**KIRKLEES METROPOLITAN COUNCIL
INVESTMENT & REGENERATION SERVICE**

Reference No: 2021/62/92000/W

Site Address: 4, Grimscar Avenue, Birkby, Huddersfield, HD2 2TU

Description: Erection of two storey side and rear extensions, dormer windows to rear and associated alterations (within a Conservation Area)

Ground Floor Layout 1.50

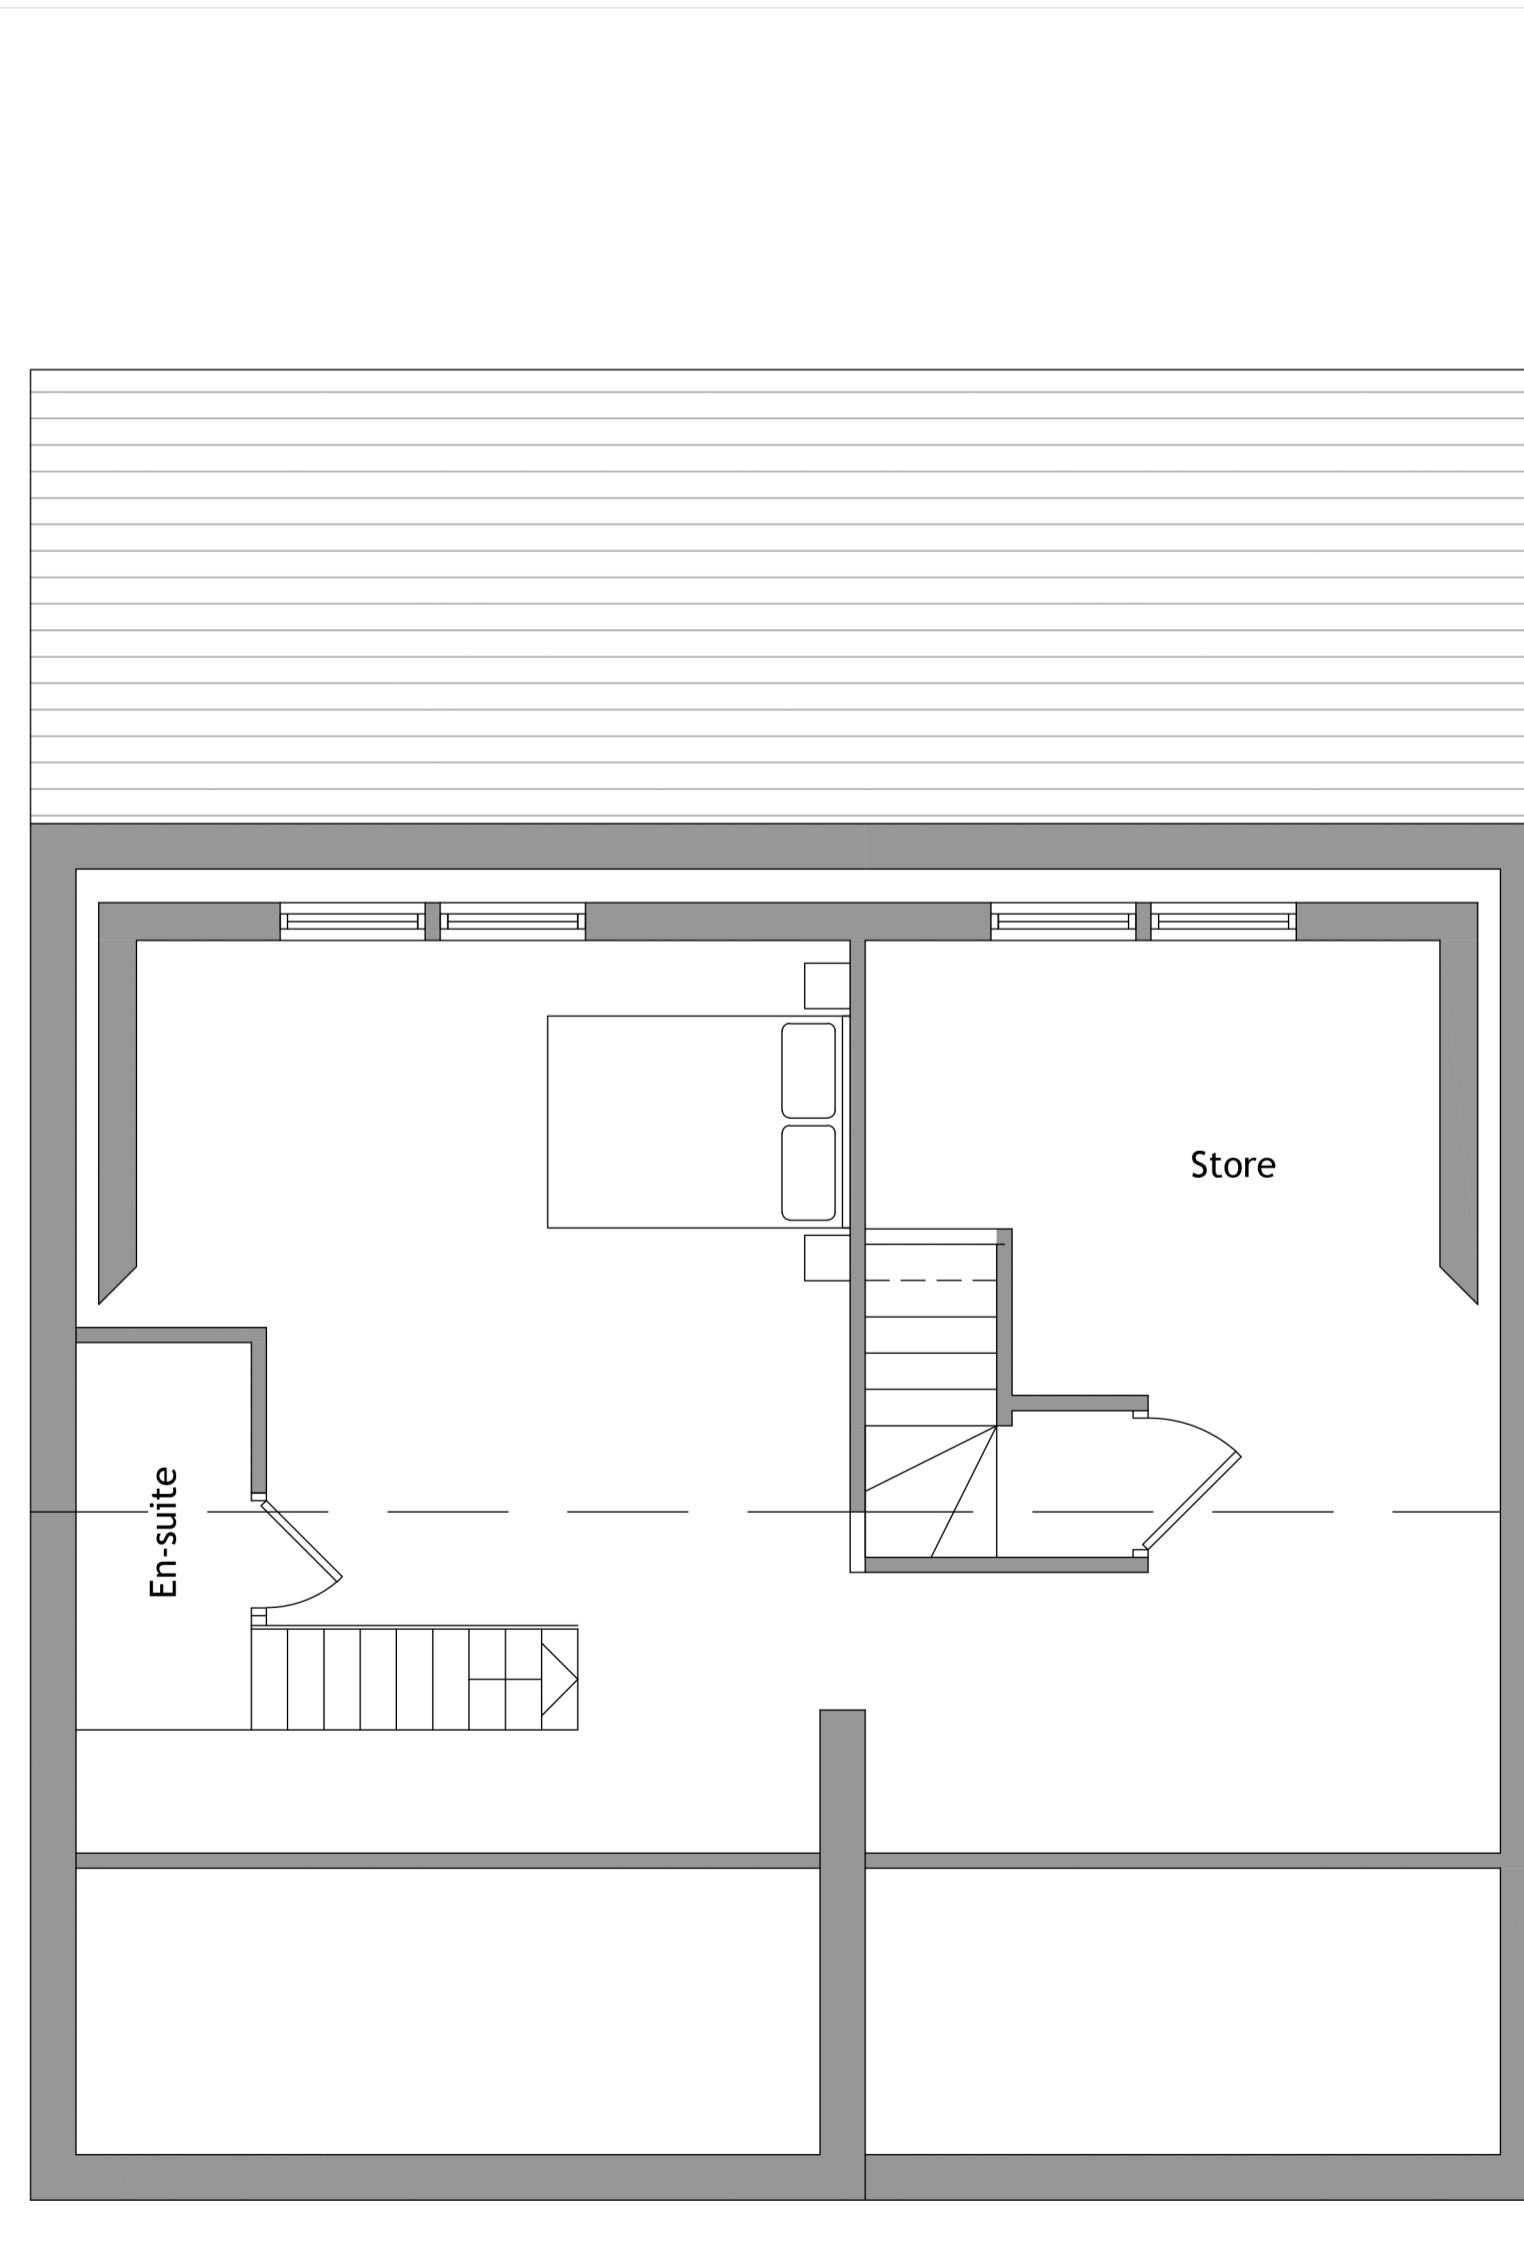
The proposal includes a 2-storey side extension which would project from the gable by 4.5m almost up to the boundary by 9.1m the depth of the host property. The side extension will be flush with the front elevation and the ridge line running through.

The proposed 2-storey rear extension would project 3m by 10m, the width of the host property and proposed side extension. The roof would have a shallow catslide, a continuation of the main roof. Given the position of the extension there will be approx. 1.4m to the rear boundary.

The proposal also includes a rear dormer in the host property and side extension, having a width of 9.4m with twin gables and the ridges in line with the host property.

The drawings indicate a basement with access from the garden and main property however no layout has been submitted for this

The proposed 'L' shaped extension would be built almost to the side boundary along Bleasdale Avenue with only a max distance to the boundary of 1m which tappers down to almost 0.1m towards the corner and front of the property. To the rear of the property the extension would be approx. 2m away from the rear boundary again this would be reduced to 1.3m due to the tapering site boundary. Resulting in no amenity space remaining for the property to the side or rear, with only the small front garden remaining untouched.

Front Elevation 1.100

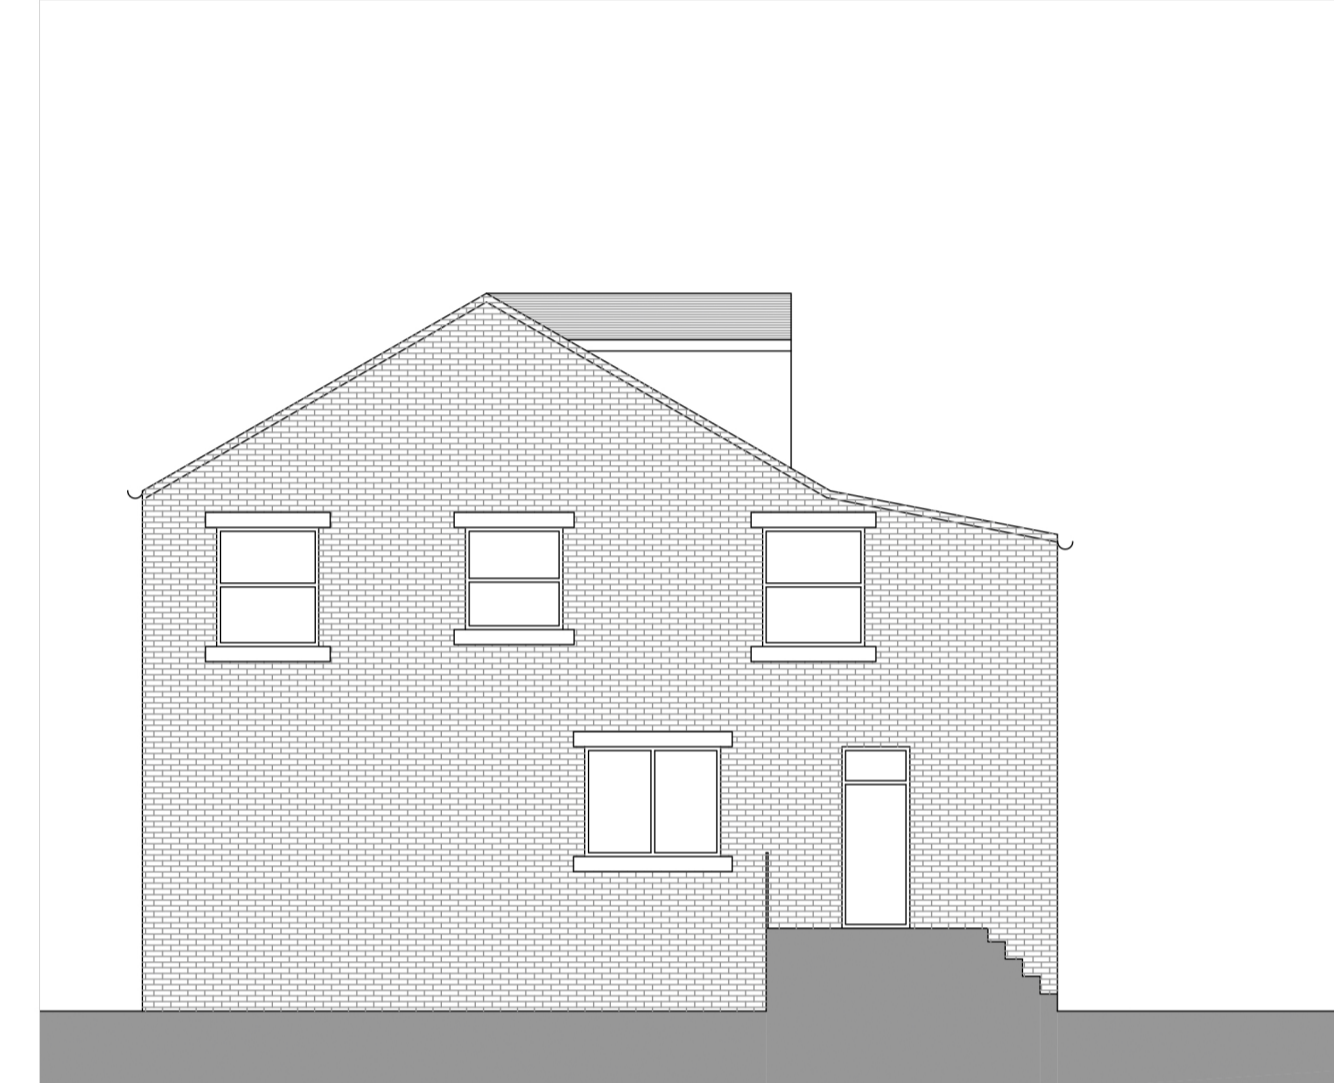
The proposed side extension would double the width of the property and extend beyond the building line of the terrace along Bleasdale Avenue, causing harm to the rhythm of the street pattern which is a characteristic feature of the repetitive terraced streets in this conservation area and contributes to its significance.

The proposal for a rear extension with a shallow catslide roof will also change the characteristics of this simple house by adding a roof pitch which is out of

character with the form of the surrounding buildings and the host building itself. In addition, a pair of large dormer window extensions are proposed on the rear pitch and these will certainly harm the character of the conservation area by adding a dominant roof feature in this prominent location where simple pitches are characteristic, along with the more unusual half dormers on the south side of Bleasdale Avenue.

The proposed extensions and dormers do not preserve and enhance the character of the conservation area as they introduce a dominant extension with substantial dormers and a catslide roof to the rear. The scale of the extensions does not respect the surrounding character or street scene and they are overbearing.

However, the proposed side extension at No 4 Grimescar Avenue would be very prominent within the street scene given the sloping site, and albeit materials match the host building along with the front fenestration details, due to the size of the extension and proximity from the boundary and the additional rear projection having a shallow catslide would represent an incongruous feature within the street scene. These comments are also reflected in the Conservation Officers comments above.

The properties to the rear are in the form of a row of terraces located at right-angle to the host property with the gable facing the rear elevation, albeit there are no windows in the gable, therefore no overlooking in this case would occur. The rear windows in the side extension would overlook both the uses of the footpath given the distance of 1.3m and the front gardens of properties along Bleasdale Avenue. It is accepted that the gardens are front gardens having an open aspect however the new relationship with the proposed side extension rear windows and the separation distance is considered to be unacceptable.

With regards the side elevation, currently there is a ground floor hall window and a secondary window to the living room along with a first-floor window to a small bedroom. The proposed extension proposes to repeat the living room side window and 2 further secondary windows to the two first floor bedrooms. These windows would result in a separation distance of approx. 15m, to the property opposite no.41 Bleasdale Avenue, which is considered to be the minimum acceptable distance, where these windows could be conditioned to be obscurely glazed if the principle of the development was considered to be acceptable.

Site Plan 1.500

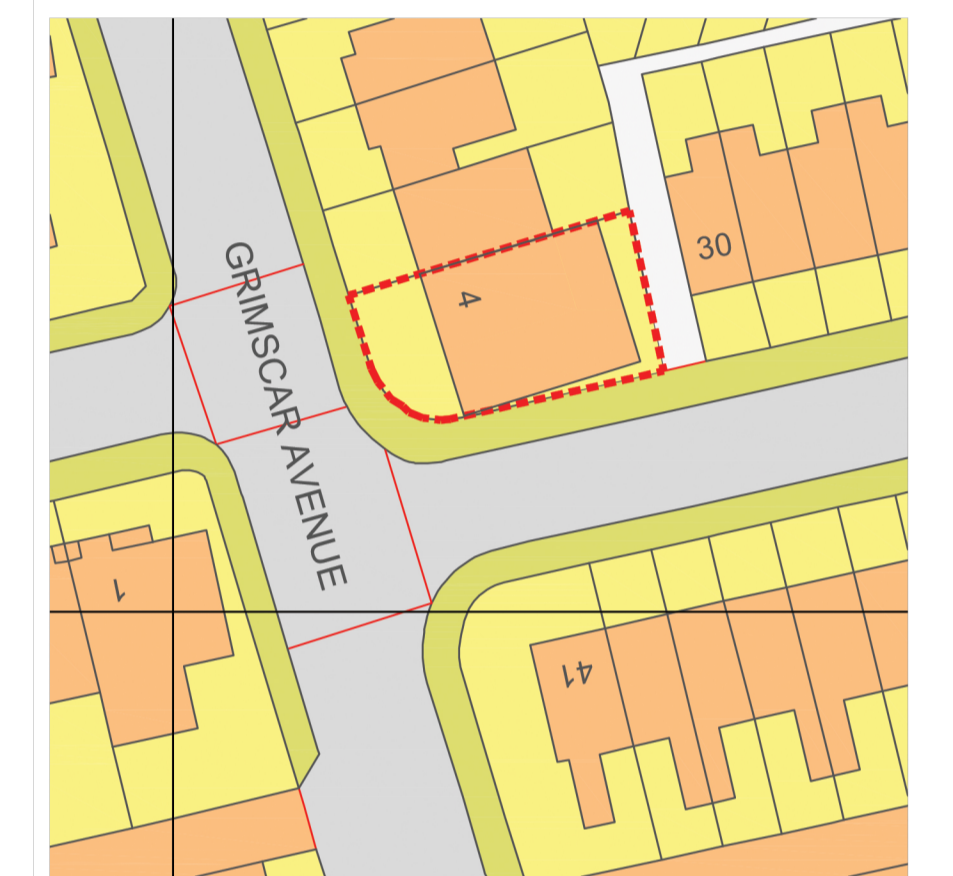
Furthermore, the host property and its associated curtilage are of a very modest size and, given the level of extensions proposed, would have no meaningful amenity space remaining. As such, the scale is considered not to be acceptable, as it would substantially overdevelop the property and form an incongruous feature, given the limited space remaining around the property. Having taken the above into account, the proposed extensions would cause significant harm in terms of visual amenity for both the host dwelling and the wider street scene within Birkby Conservation Area. The application, therefore, fails to comply with policy LP24 of the KLP (a) in terms of the form, scale and layout and (c) as the extension would not form a subservient addition to the property in keeping with the existing building and the aims of chapter 12 of the NPPF.

In terms of highway safety, the existing garage and off-street parking spaces will be lost, given that the accommodation being provided would be 5 bedrooms, 3 parking spaces would be required. Therefore, on street parking would be inevitable. On street parking in the local area can be oversubscribed and there is concern that the proposal would have a detrimental impact on highway safety contrary to Policy LP21.
